# Norwich to Tilbury

**Document: 8.3.36 Draft Statement of Common Ground - Priory Farm  
Airfield - Clean Version**

**Planning Inspectorate Reference: EN020027**

# Priory Farm Airfield

Image A15.2.1 Climb-out over Overhead Line - Low and High Performance Single Piston Engine Aircraft

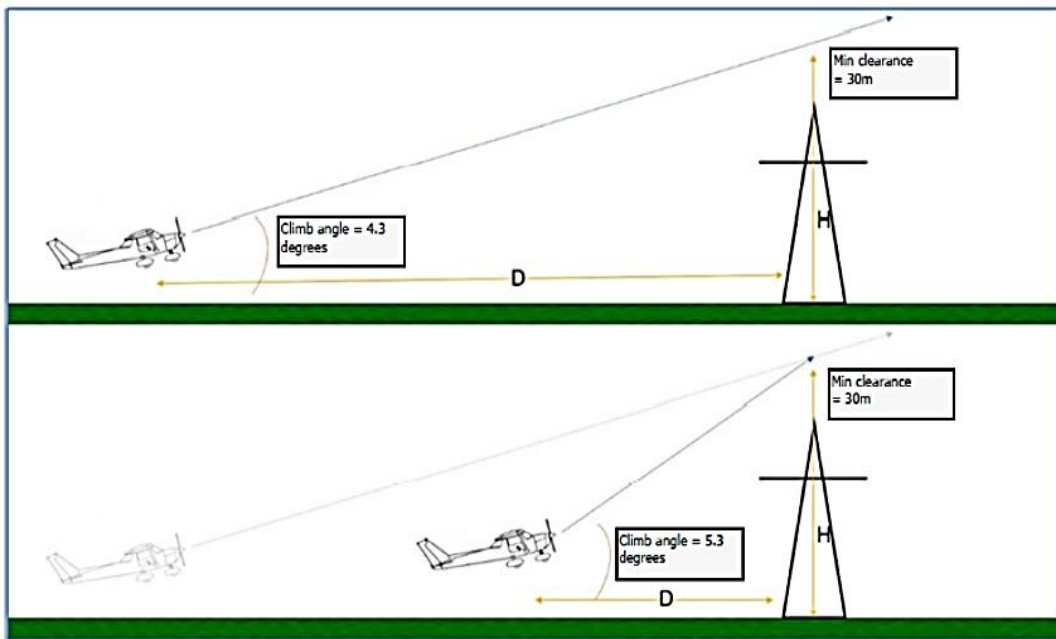
ID	Issue	Priory Farm Airfield position (including date)	National Grid response (including date)	Relevant documentation
7.3	Aviation Impact Assessment Methodology and Key Assumptions	<ul style="list-style-type: none"> <li>• There appears to be an overreliance on theoretical modelling: All of your clearance assumptions rely on idealised aircraft performance and standardised circuit behaviour.</li> <li>• But real-world conditions – wind shear, engine issues, human error, bird activity – are NOT factored in.</li> <li>• Your assessment assumed ideal climb-outs and fixed circuits, but light aircraft regularly depart or return using modified paths based on wind, traffic, or emergencies. A model that only covers textbook operations does not address real safety.</li> <li>• There has been no meaningful consultation with the pilots who fly from here every week. The assessments do not reflect the way real flights operate, particularly for microlights or low-performance aircraft.</li> </ul>	<p>consider any key information to be missing or preventing progression of engagement. (January 2026)</p> <p>National Grid’s Aviation Impact Assessment methodology has been developed to enable site-specific impact assessments for aerodromes potentially impacted by the Project. Its primary aim is to evaluate risks of collision, predominantly during take-off and approaches and including forced landing risks, with the proposed overhead line alignment representing a new obstacle within proximity of aerodromes. Operational safety impacts arising from potential increases to risks of bird strike, wind turbulence and electromagnetic forces as a result of the Project are also considered.</p> <p>As previously stated, National Grid’s approach recognises and responds to CAP793 recommendations, albeit with the understanding its broad parameters of 150ft/2000m are generalised suggestions for owner and operator consideration in relation to airfield design, rather than absolute requirements to be addressed by prospective developers. The methodology enables a bespoke appraisal, appropriate to each aerodrome, that considers a range of factors in</p>	5.15 Design Development Report [APP-122]

ID	Issue	Priory Farm Airfield position (including date)	National Grid response (including date)	Relevant documentation
		<ul style="list-style-type: none"> <li>We would also add that Priory Farm has published procedures both online and through popular navigation aids such as SkyDemon and Pooleys.</li> <li>Utilising these aids it is difficult to see how the pylons can have anything but a significant adverse effect on both our 500' and 1,000' circuits.</li> <li>It should also be obvious that the proximity of Tibenham leaves zero margin for movement eastwards.</li> </ul> <p>(July 2025)</p> <p>Priory Farm raised concerns that details of impact assessments have not been shared with the operator or published.</p> <p>(August 2025)</p>	<p>addition to the height and location of the proposed overhead line alignment, including: runway length and orientation in relation to the overhead line; aircraft types, performance, flight paths and operational procedures (determined from published information, as well as from previous engagement) and the surrounding context in terms of topography, existing obstacles (including other overhead lines) and neighbouring aerodromes (recognising operational deconfliction constraints). The assessments consider whether the Project alignment infringes Obstacle Limitation Surfaces (OLS) as specified under the CAA's CAP 168 regulations for licensed aerodromes, recognising this to be a best practice measure for obstacle assessment and treatment, whilst not a regulatory requirement for unlicensed aerodromes. If CAP168 measures are met, the proposed overhead line alignment is considered to have an acceptable impact on the aerodrome's operations and no further changes are considered likely to be necessary.</p> <p>(March 2025)</p> <p>National Grid is receptive to feedback regarding the methodology and key assumptions, and welcomes the opportunity to</p>

ID	Issue	Priory Farm Airfield position (including date)	National Grid response (including date)	Relevant documentation
			<p>test these using ‘real world’ data to ensure a robust and objective approach. Notwithstanding National Grid’s stated position in relation to CAP 793 parameters, we would be grateful for Operator clarification of what would be an acceptable clearance, and further welcome the sharing of Operator data, including published information to ensure it has been duly considered. (August 2025)</p> <p>National Grid has submitted a Review of Aviation Impact as an appendix to the Environmental Statement accompanying the DCO application. This appendix describes National Grid’s aviation assessment scope, approach and conclusions, as outlined in relation to Priory Farm within this SoCG. Should the DCO application be accepted for examination, the appendix will be published by the Planning Inspectorate, and National Grid will share the document with operators. (September 2025)</p> <p><b>6.15.A2 Environmental Statement Appendix 15.2 - Review of Aviation Impact</b> explains how relevant CAA guidance, as well as consultation with aviation bodies and</p>
